Technical Memorandum 8 (AAH TM08)

Lincolnshire County Council, Meridian Solar: Deadline 1 document review

AAH Consultants, on behalf of Lincolnshire County Council (LCC) have reviewed the Deadline 1 document responses. These include:

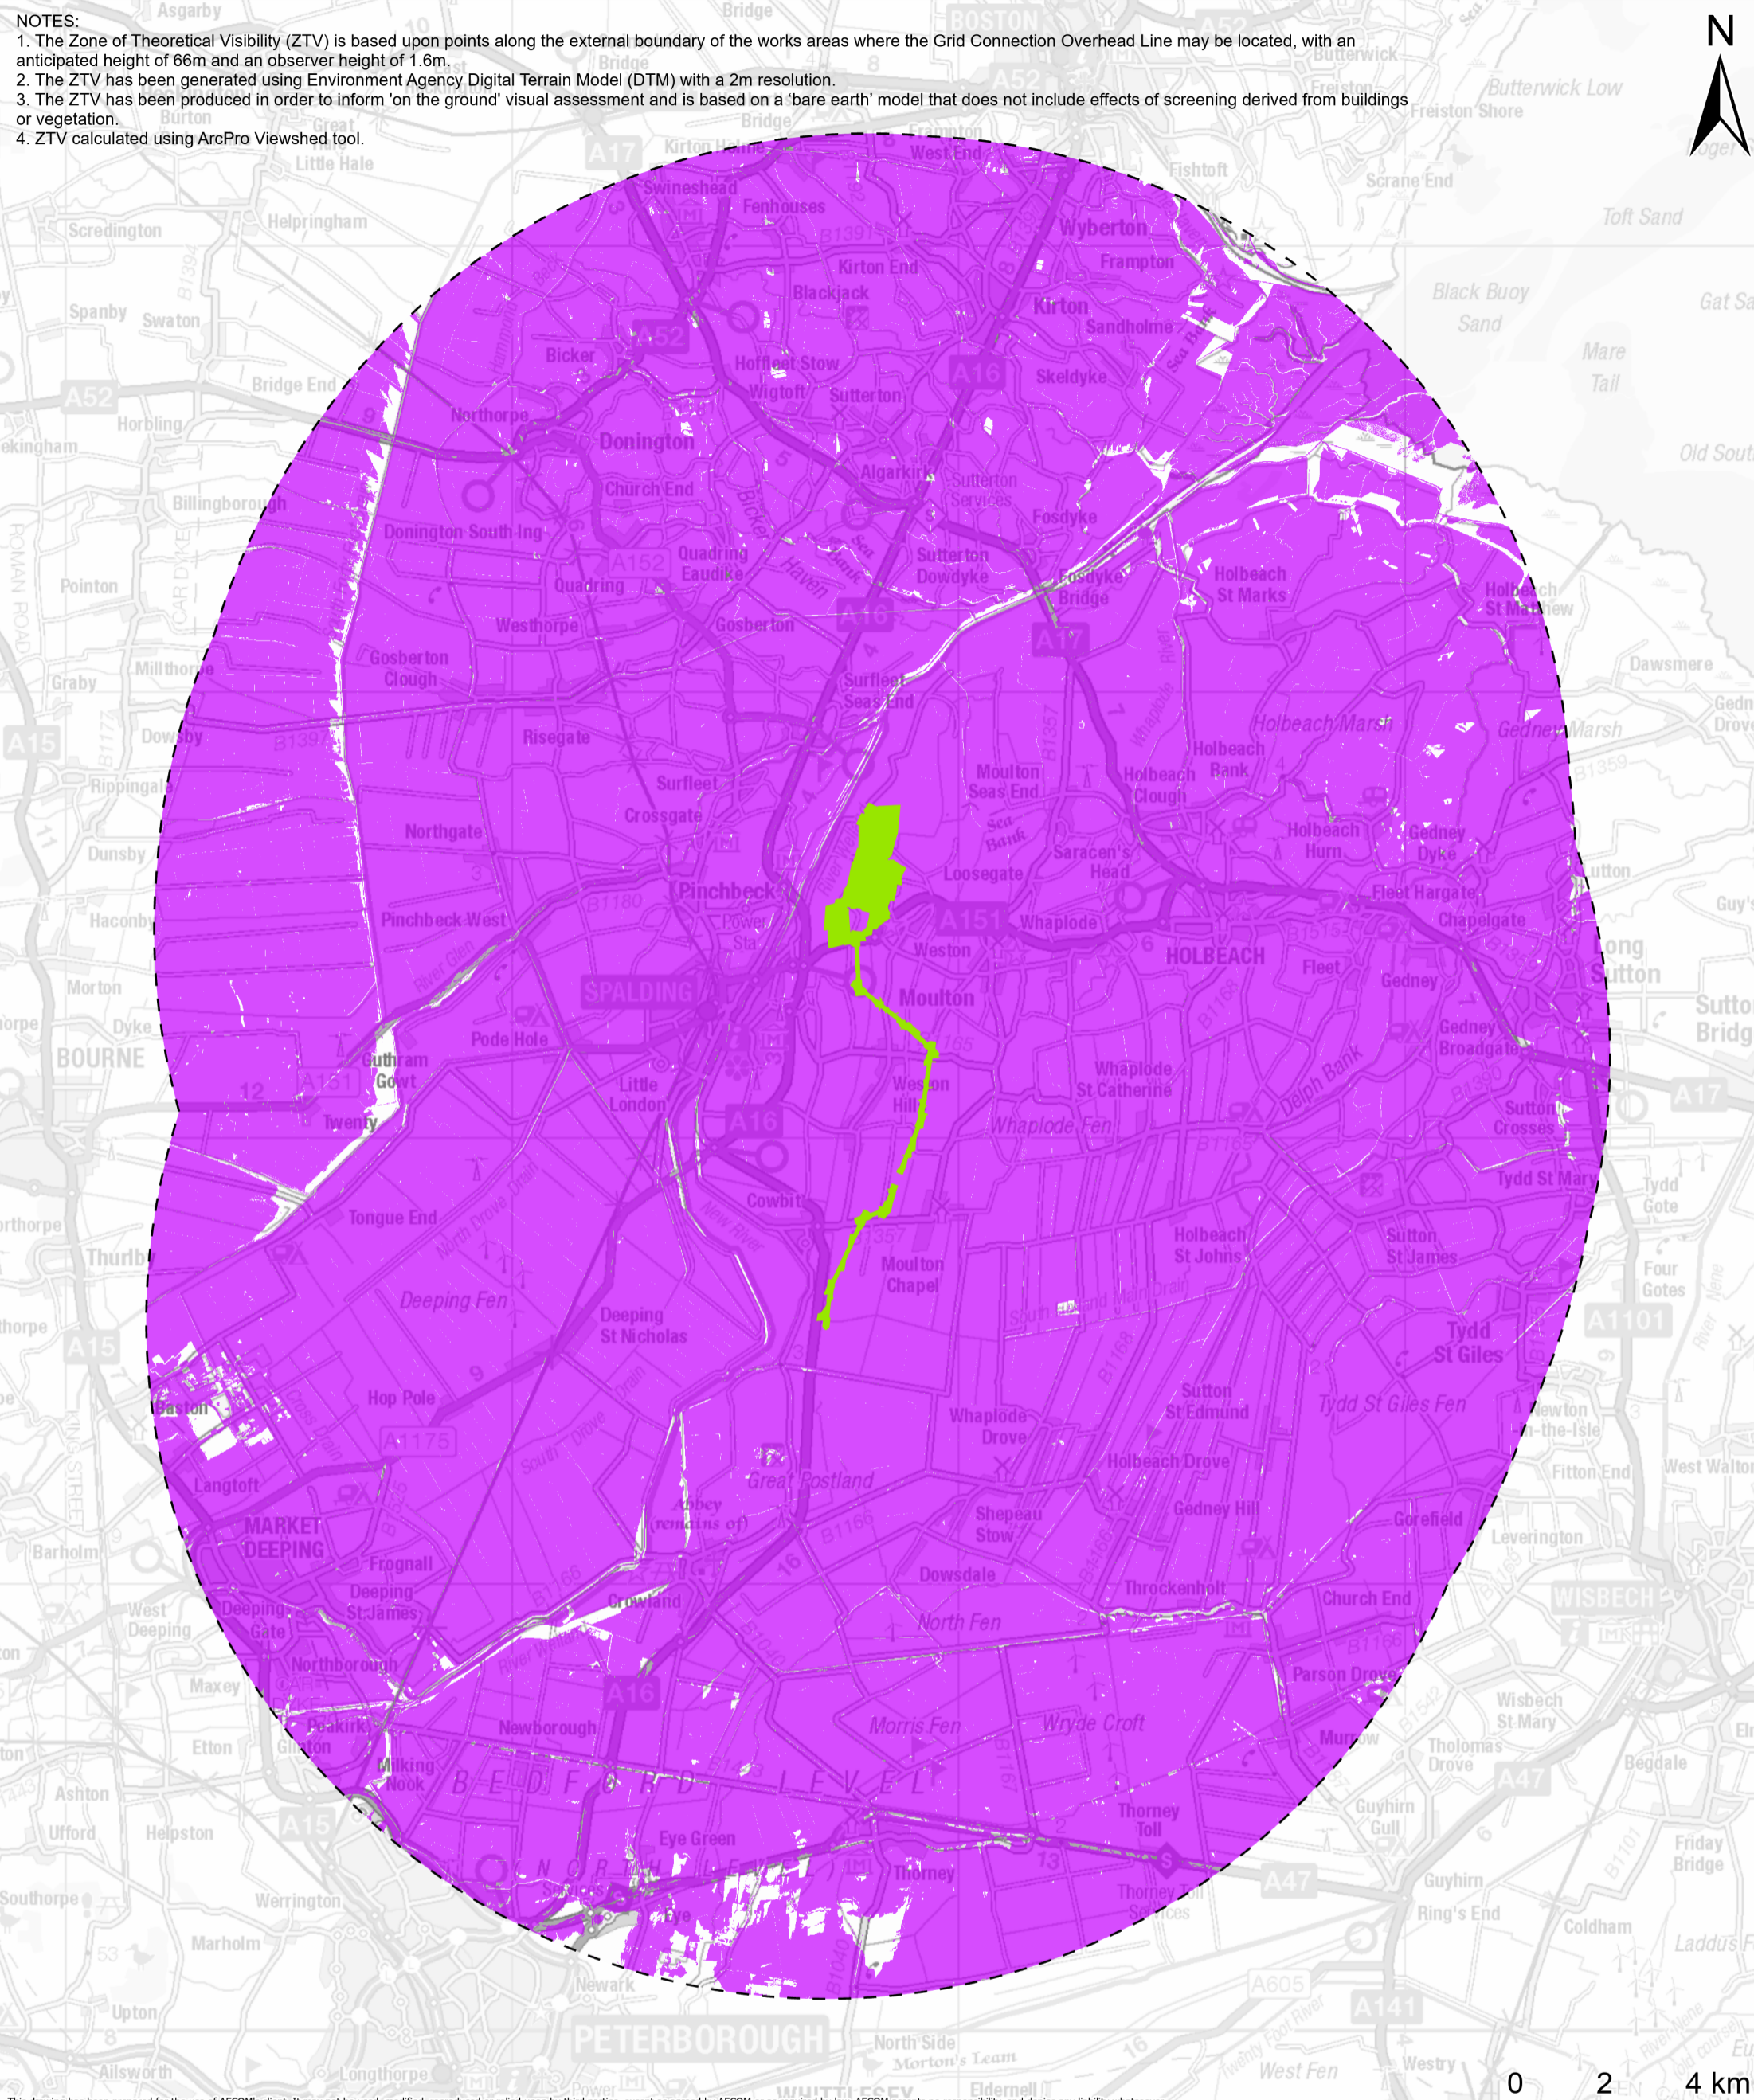
Regarding the Grid connection route, ‘all landscape and visual effects reported with respect to the Grid connection Route infrastructure are moderate adverse’. The Applicant has understood that only effects that ‘exceed moderate adverse’ (in EN-5) are considered significant and undergrounding is not required and this approach is consistent with national policy (p30 - RR). It is not clear why the Applicant has applied a higher threshold for significance in this instance when their own LVIA methodology (p21 – Meridian LVIA) shows clearly that moderate effects can be assessed as ‘significant’.

Summary: the Applicant acknowledges many of the general points raised in the RR by South Holland District Council but commits to no further changes or updates to their design approach or report work. The only additional information provided are the winter views in the Additional Winter Photography Technical Note (Ref 8.8). The Applicant is inaccurate regarding the potential need for RVAA and the LA has the right to request one if they deem it necessary. The significant impact of the Grid Connection infrastructure on the landscape and visual setting seems to have been

understated and it is concerning that no landscape mitigation is proposed for this route apparently under the pretext of protecting Fenland character.

In Conclusion, the Applicant reiterates that there is no landscape design for the Grid Connection route for the reasons explained in ES Chapter 12: Landscape and Visual (APP-063) i.e. mitigation planting will not reduce the significance of the proposed infrastructure and would be out of keeping with the open landscape in this location.
